CITY OF ALBUQUERQUE

**Re: Hope Christian High School
Neighborhood Impact Analysis
Engineer's Stamp 5-15-24 (D18D009)**

The subject Neighborhood Impact Analysis received 5-16-24, has been reviewed and is approved by the City of Albuquerque Planning Development Transportation Section with the following infrastructure improvements to be constructed:

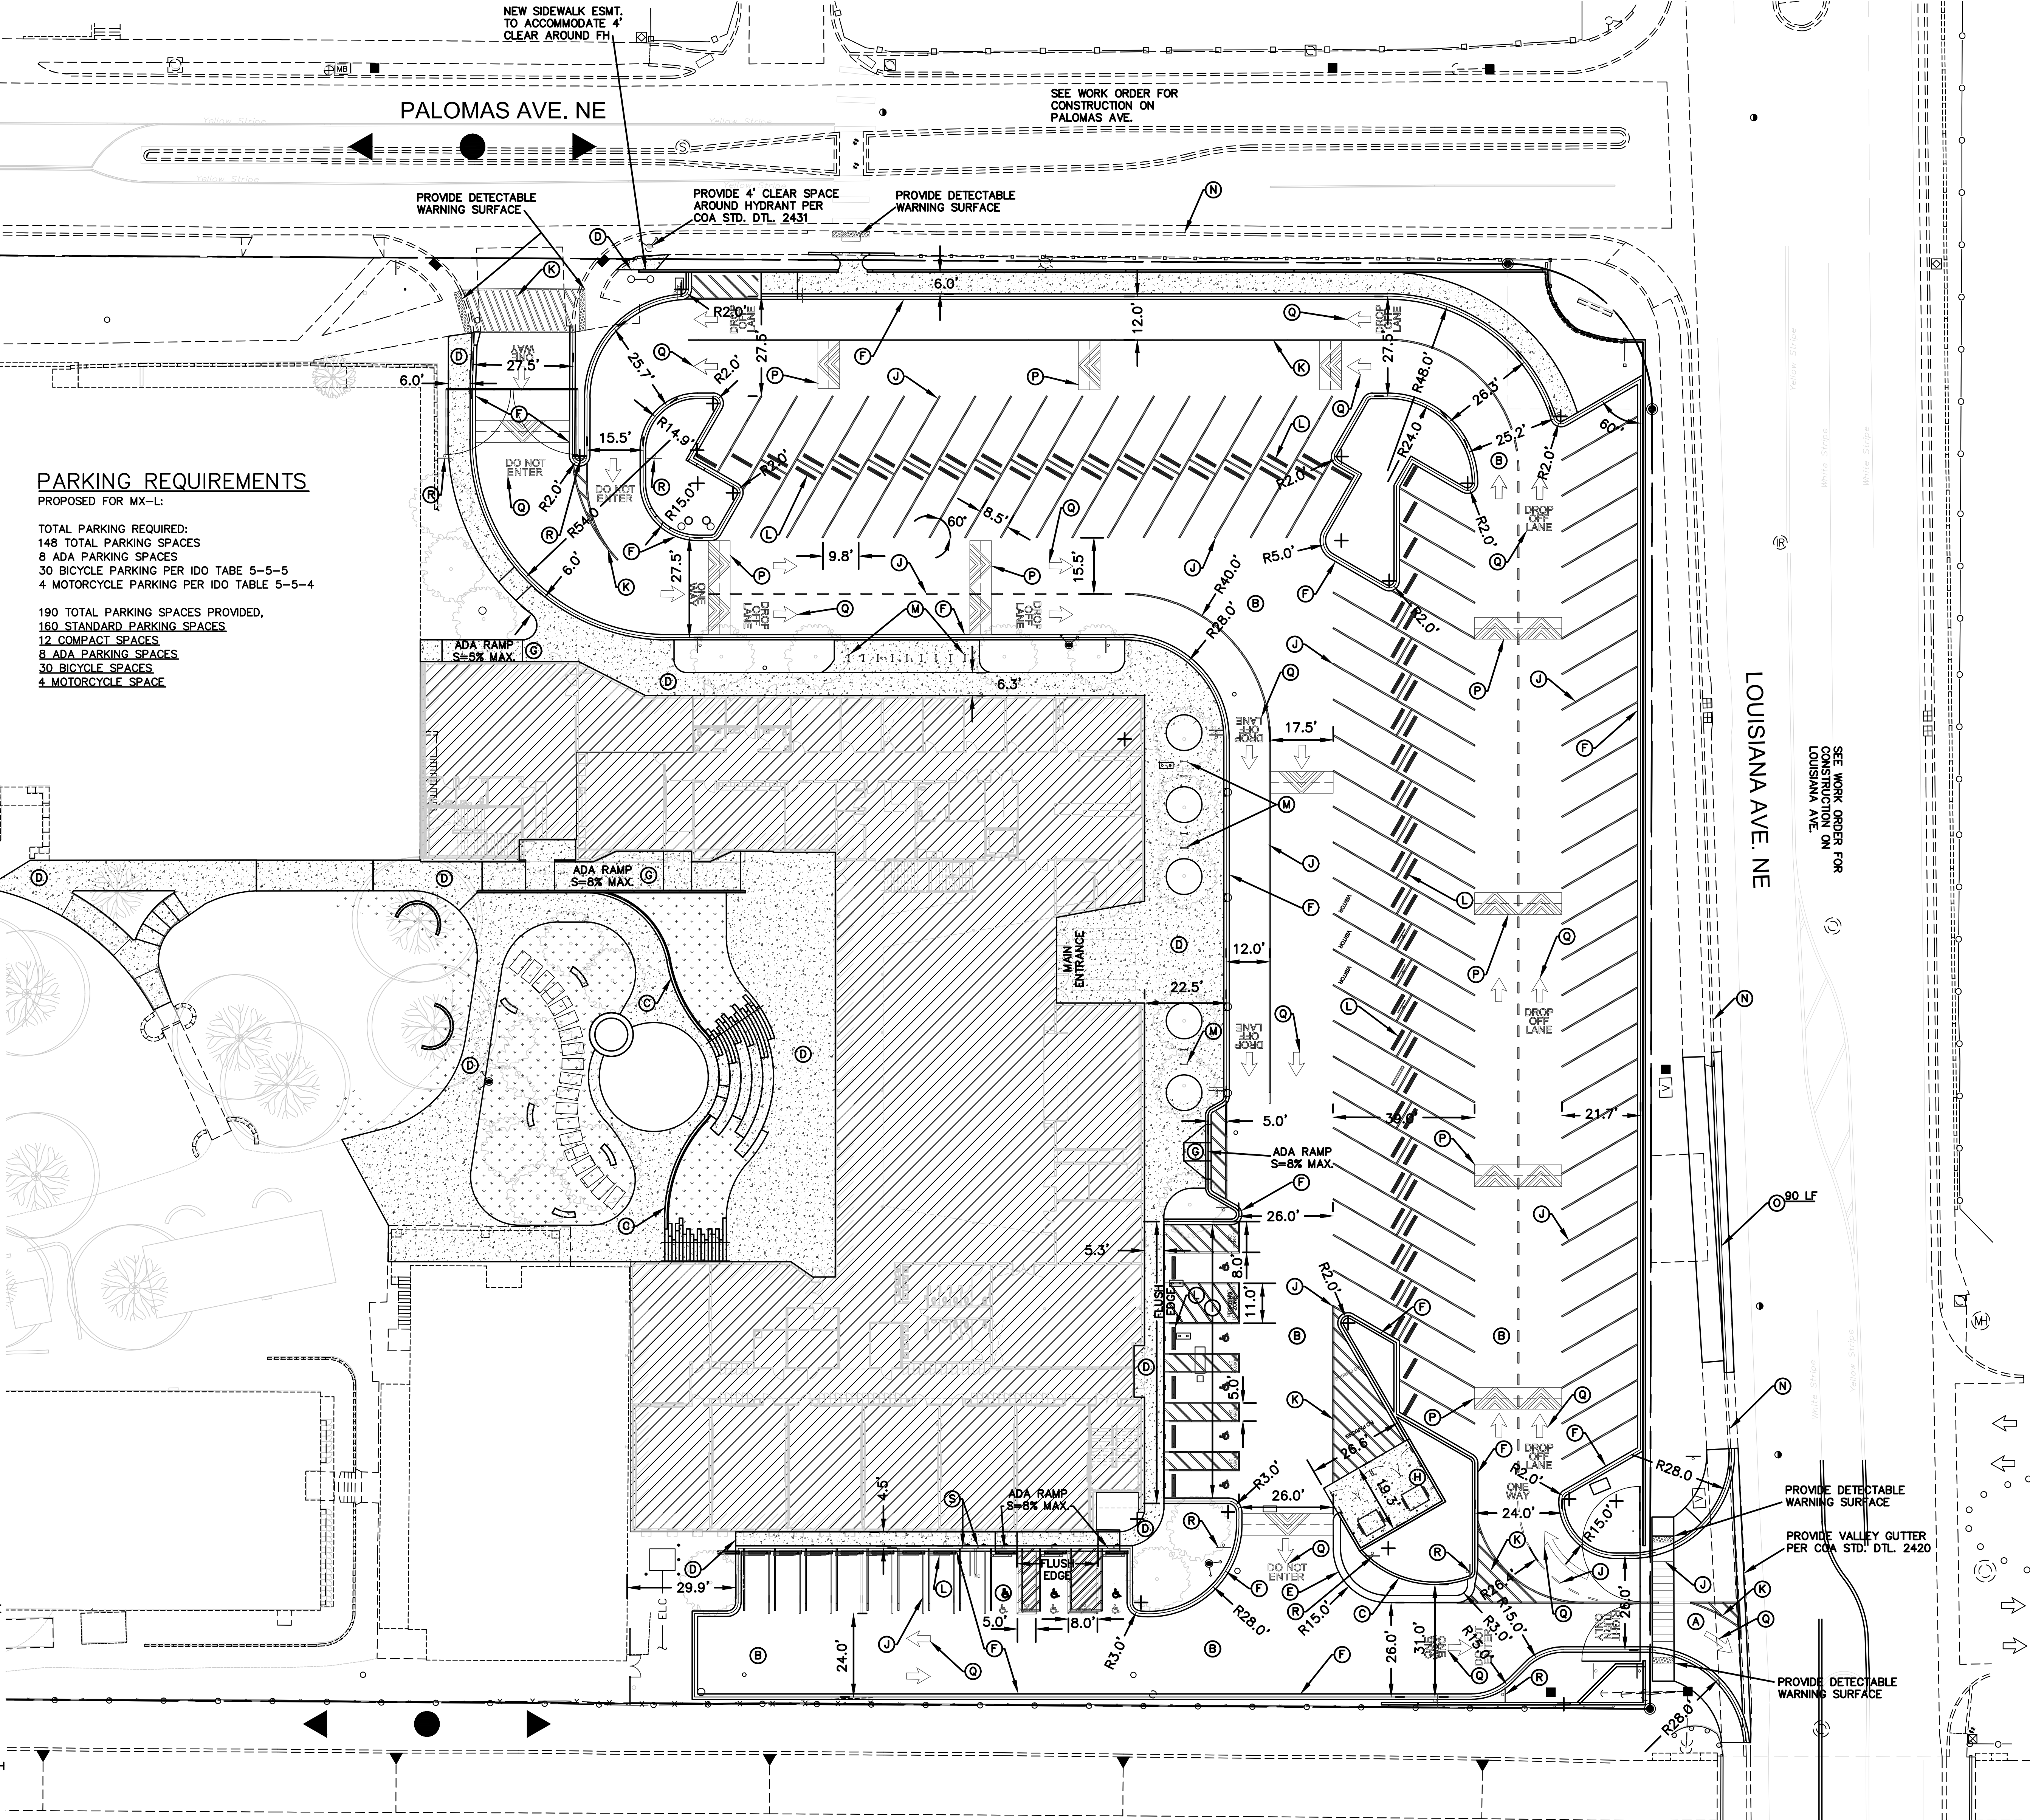
1. Revise the striping of the northbound two-way left-turn lane on Louisiana Blvd approaching the proposed Hope Christian School south driveway to a left-turn lane. Adjust the southbound left-turn lane striping at the access to the FAA facility on the east side of Louisiana Blvd, across from the proposed Hope Christian School access.
2. Convert the two-existing crosswalk on Palomas Ave. to Raised Crosswalks/Speed tables to improve pedestrian safety.
3. Properly sign and mark school zones on Palomas Ave., per MUTCD standards., in coordination with the City.
4. In areas of Palomas Ave. where there are raised medians and curb extensions; on-street parking is prohibited. Use pavement marking words (No Parking) or crosshatching in the no parking zone in addition to the painted curbs and parking restriction signs. .
